From: Andrew Wood
Sent: 10 May 2019 13:43
To: Planning.Responses
Subject: FW: M/24/19/PL - 3 The Hard, Elmer
Attachments: 789 PL001 Proposed Floor Plans Site and Location Plans REV B.pdf; 789 PL002 Proposed Elevations and Sections REV B.pdf

I respect of the above application and in response to the comments raised by the Environment Agency in their consultation, please find attached amended drawings PL001 A and PL002 A indicating the existing raised bund running east west across the site as being retained.

A EAST WEST BUND TO GARDEN RETAINED 23.04.19
REV. DESCRIPTION DATE

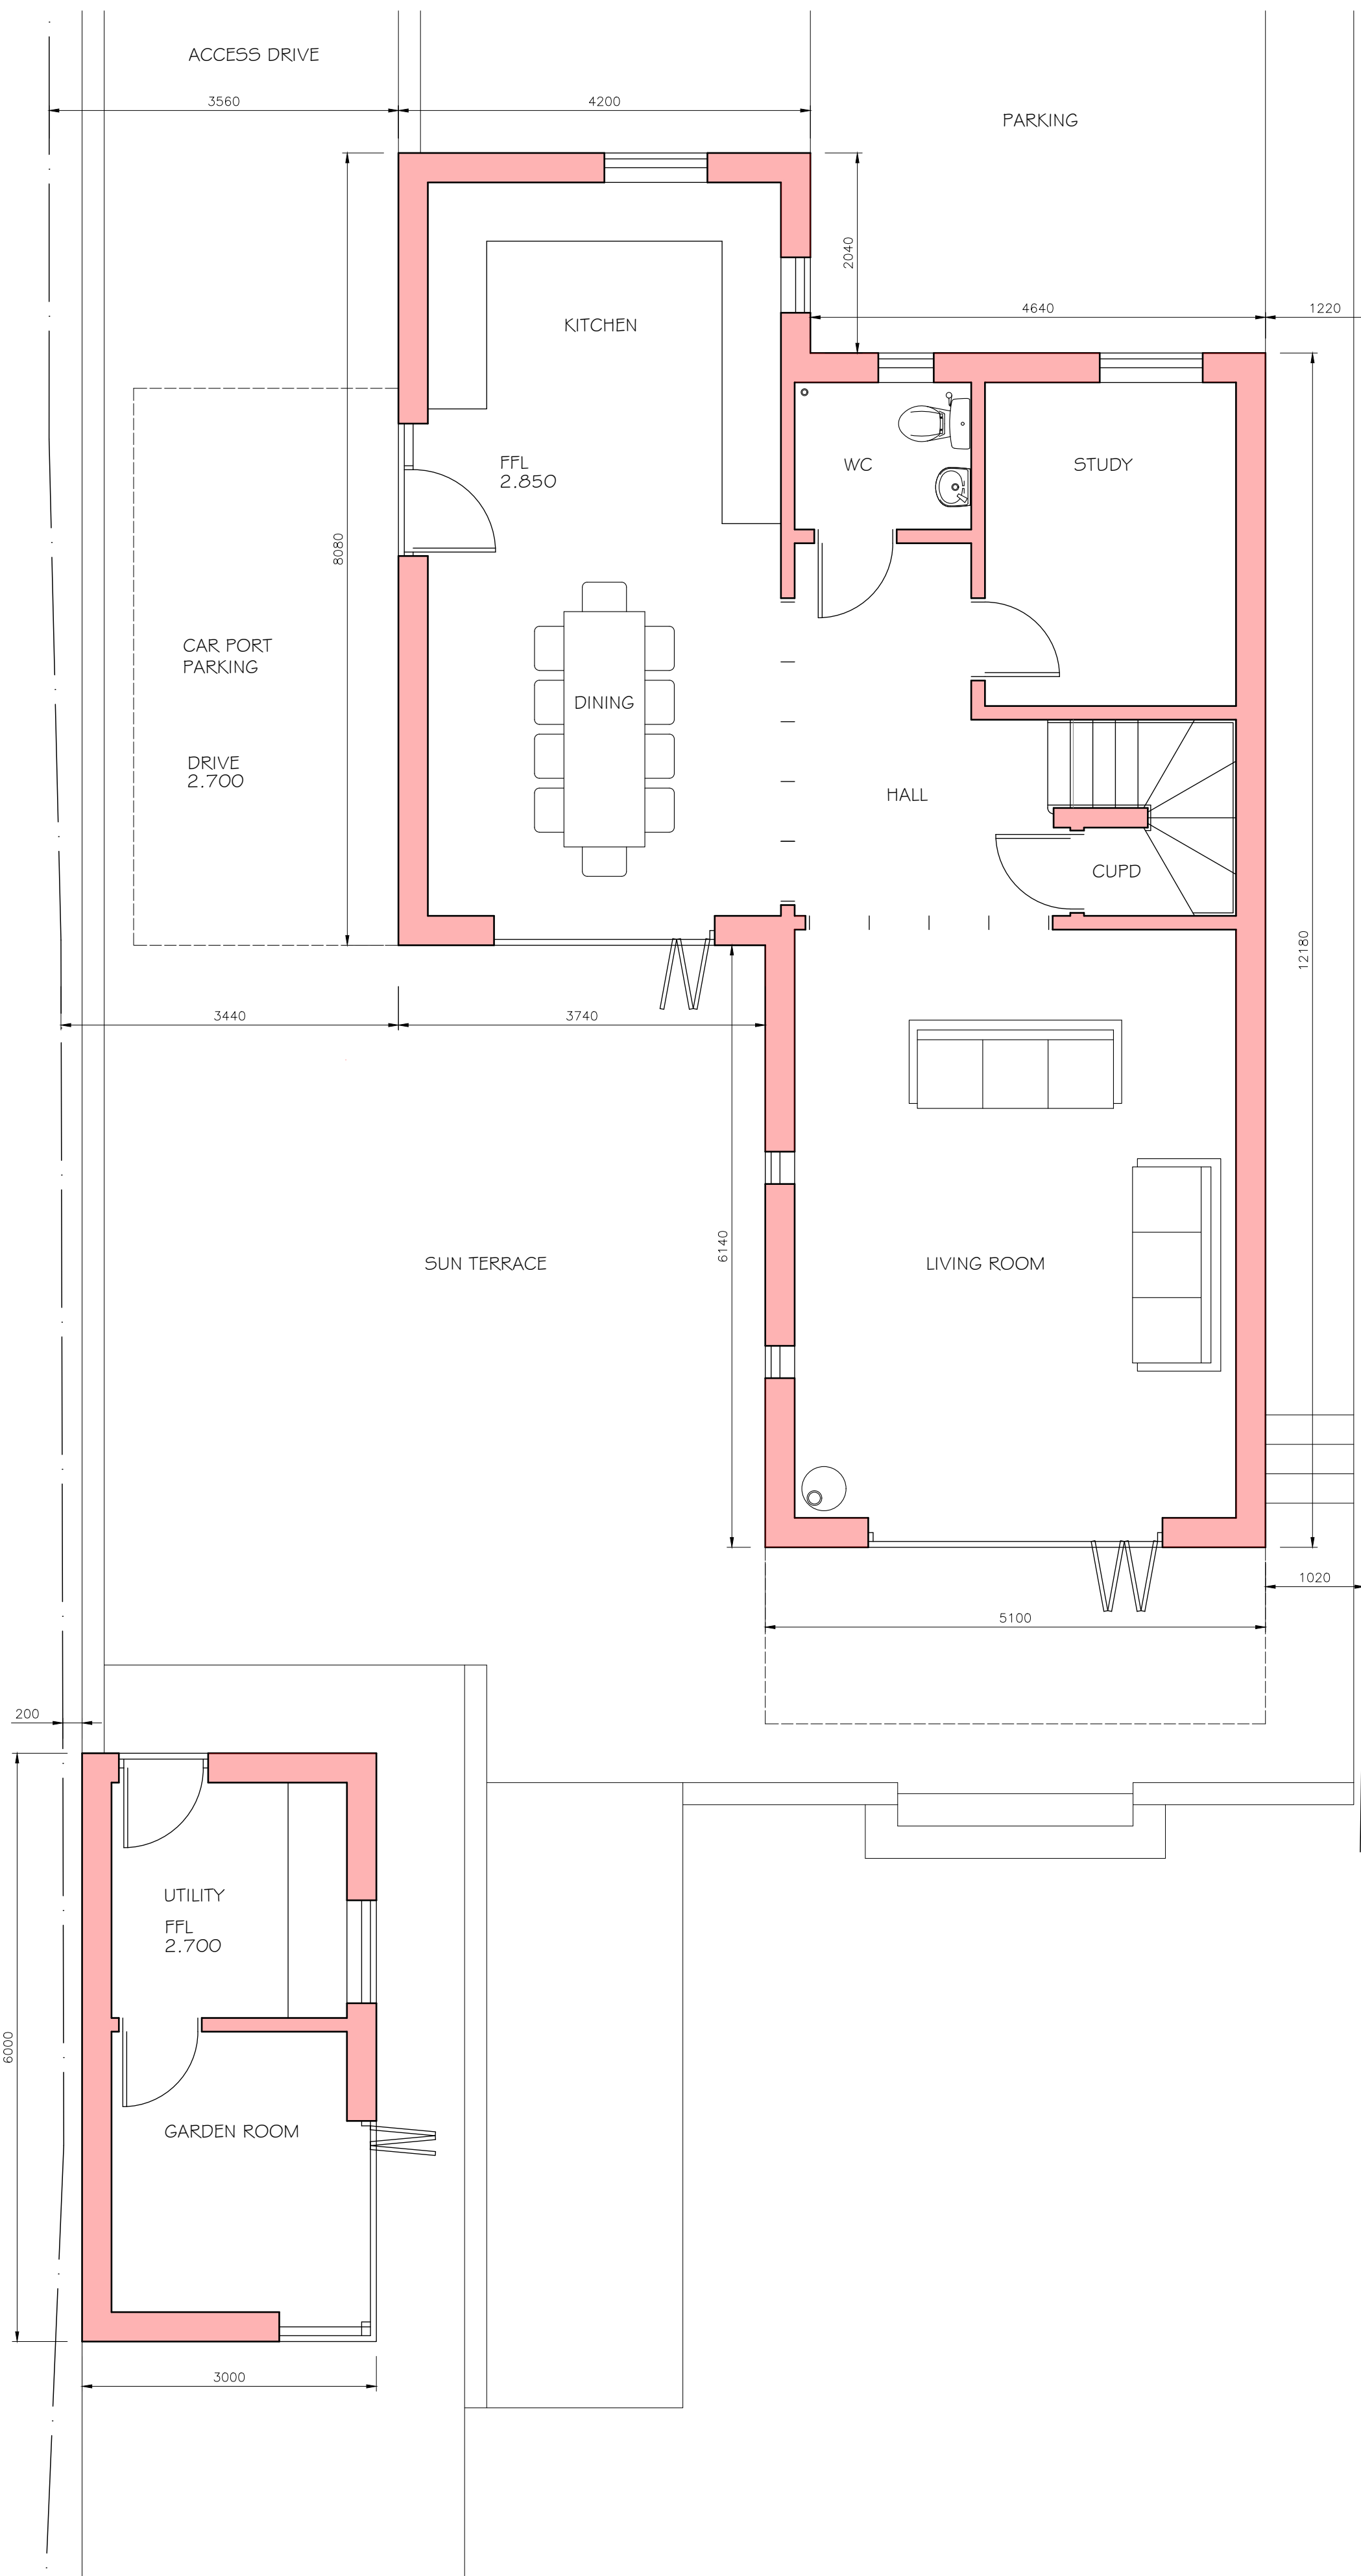
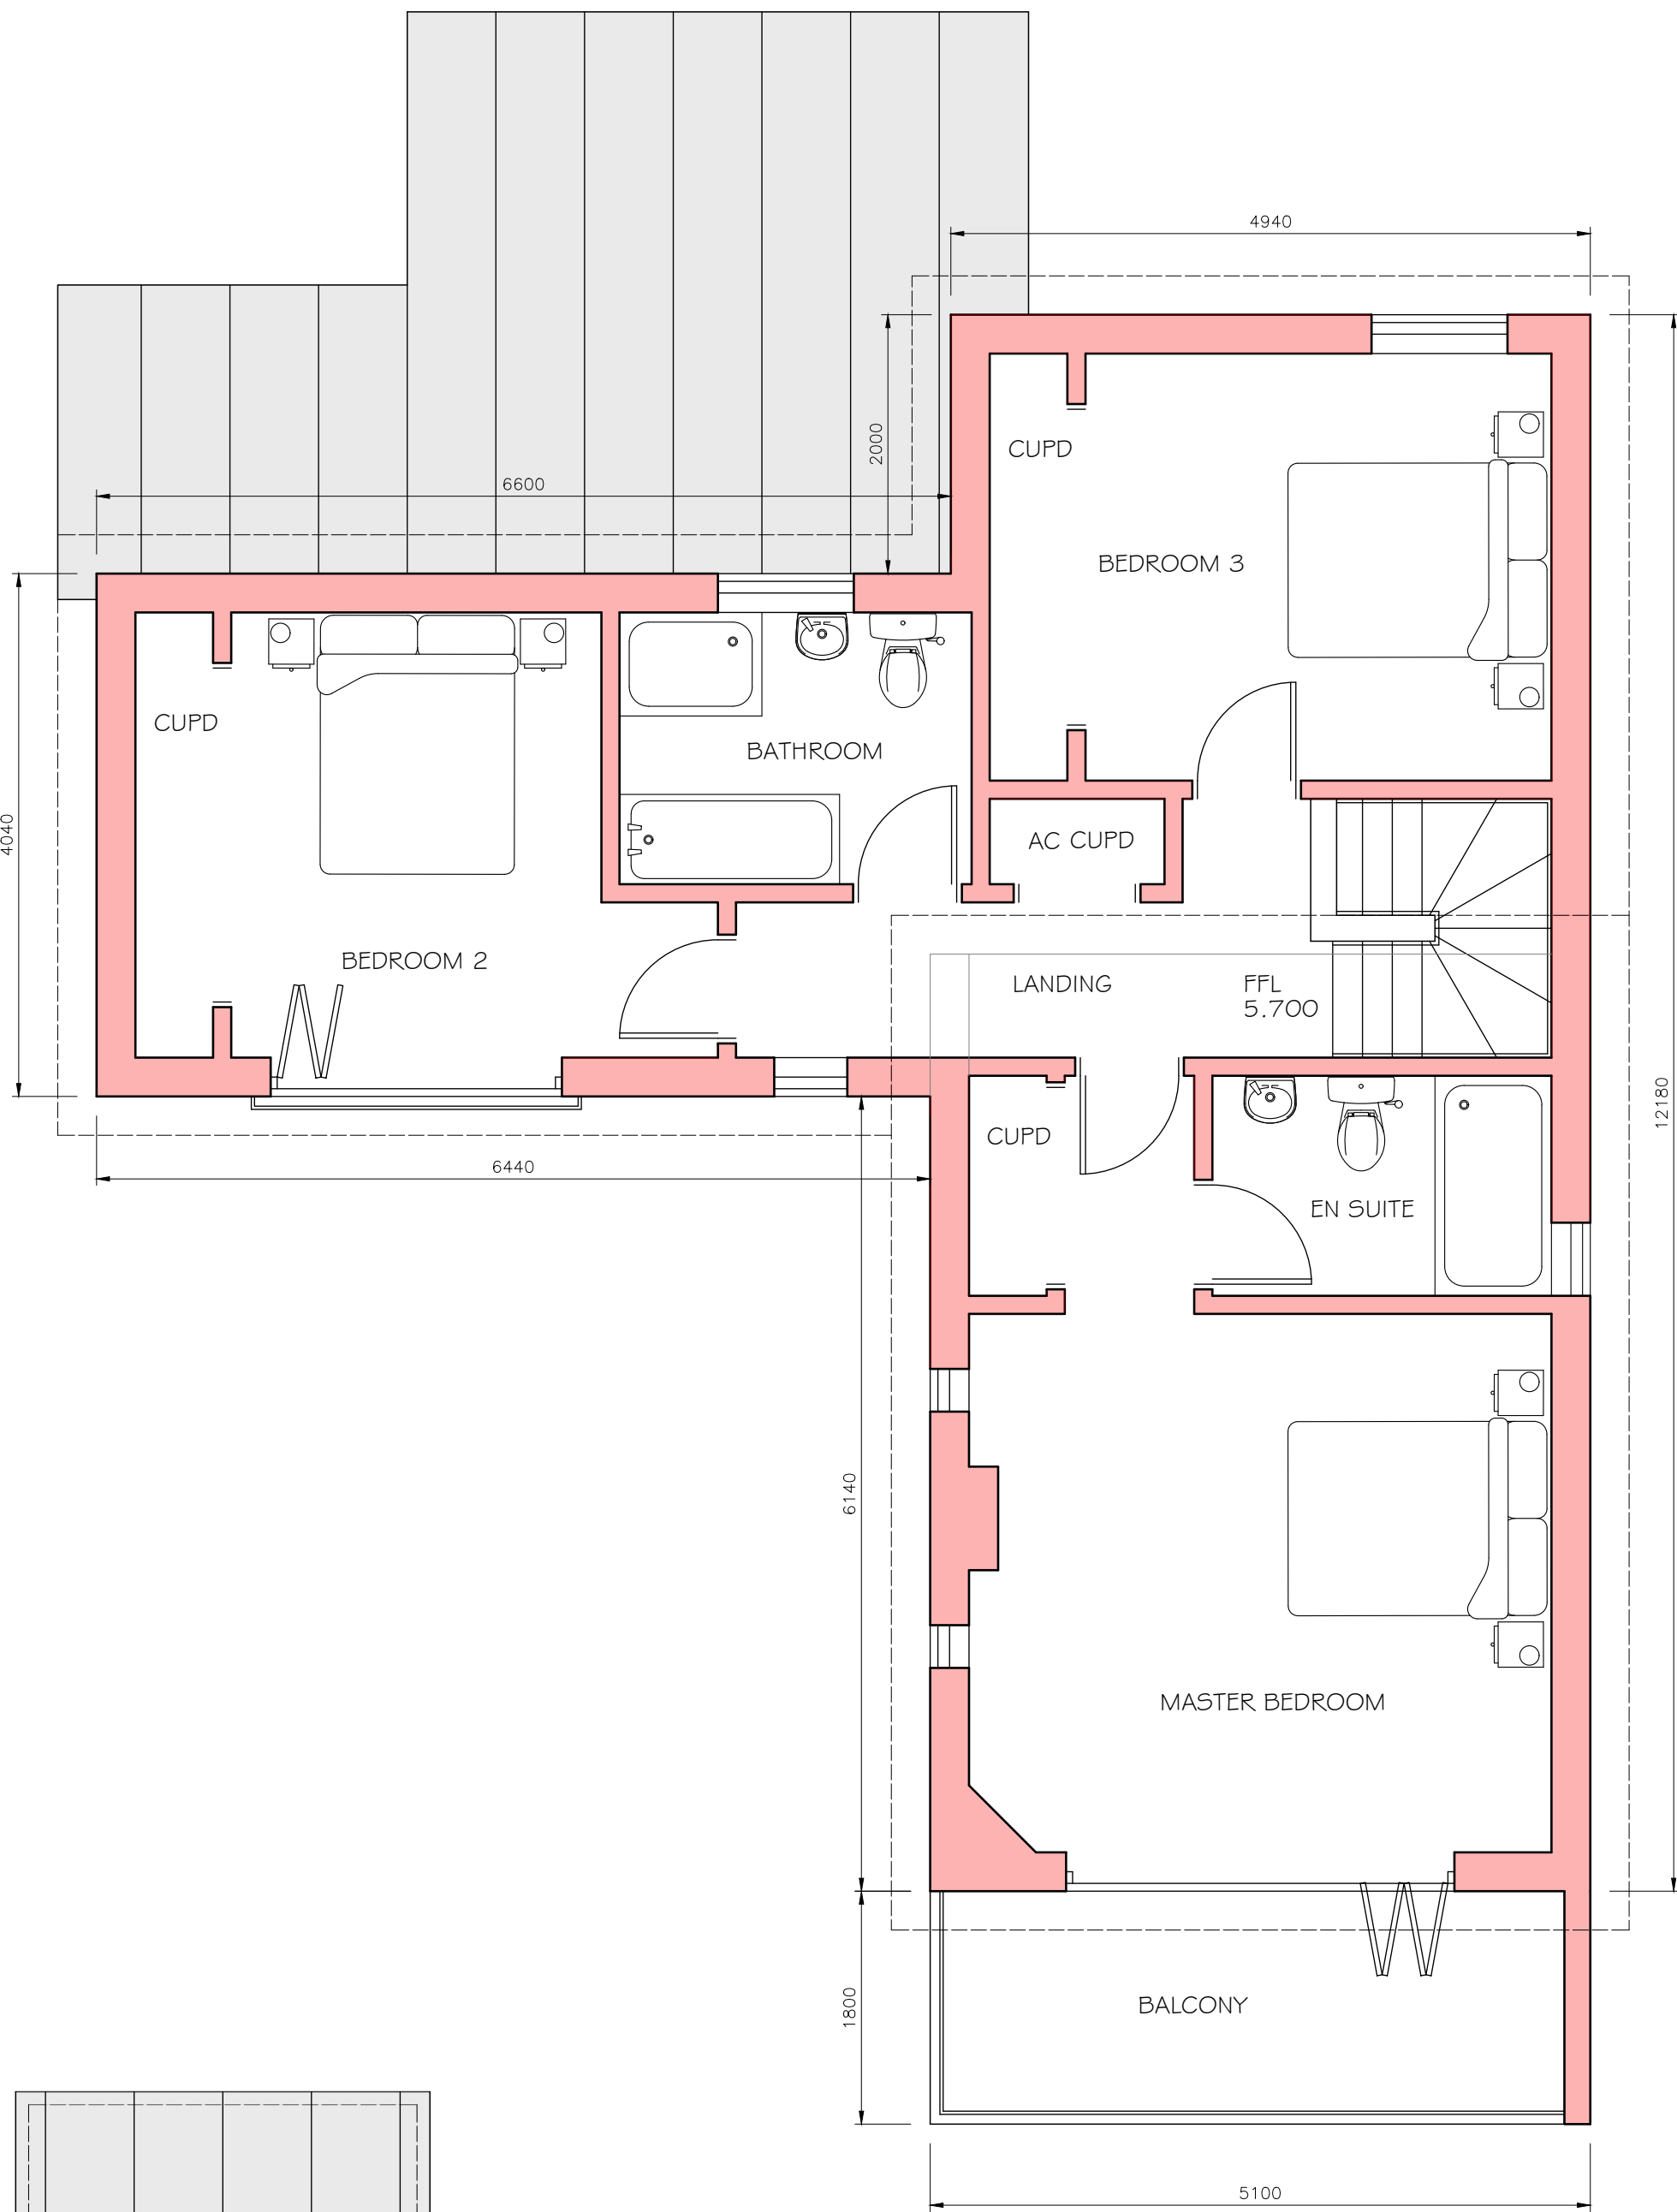
- * an obscure glazed balcony screen 1.7 metres in height on the west side of the first floor balcony serving the master bedroom.
- * Details of the two bicycle parking spaces within the rear shed mentioned in your design and access statement i.e what will they be locked to.

- * Can you please indicate that the side elevation windows will be obscure glazed and non opening below 1.7 metres in height in the case of the east elevation window at first floor level.

- * - indicate on plan and elevation where wheely bin and recycling storage cupboards will be.
- * Details of the proposed lighting scheme in accordance with the ecologist comments relating to biodiversity 'avoiding unnecessary artificial light spill through the use of directional light sources and shielding.'

1. The west elevation of the balcony to the master bedroom will be fitted with a minimum 1.7m high tapered screen comprising frosted glass to provide privacy.

6. The side window serving the master bedroom en suite will be obscure glazed at all times and be non opening.
7. The wheelie bins for general waste and recycling will be located in a stand alone timber clad 'cupboard', in the location originally indicated on the 1:200 site plan and now indicated on the 1:50 floor plan and 1:100 elevations. The timber will be western red cedar to match.
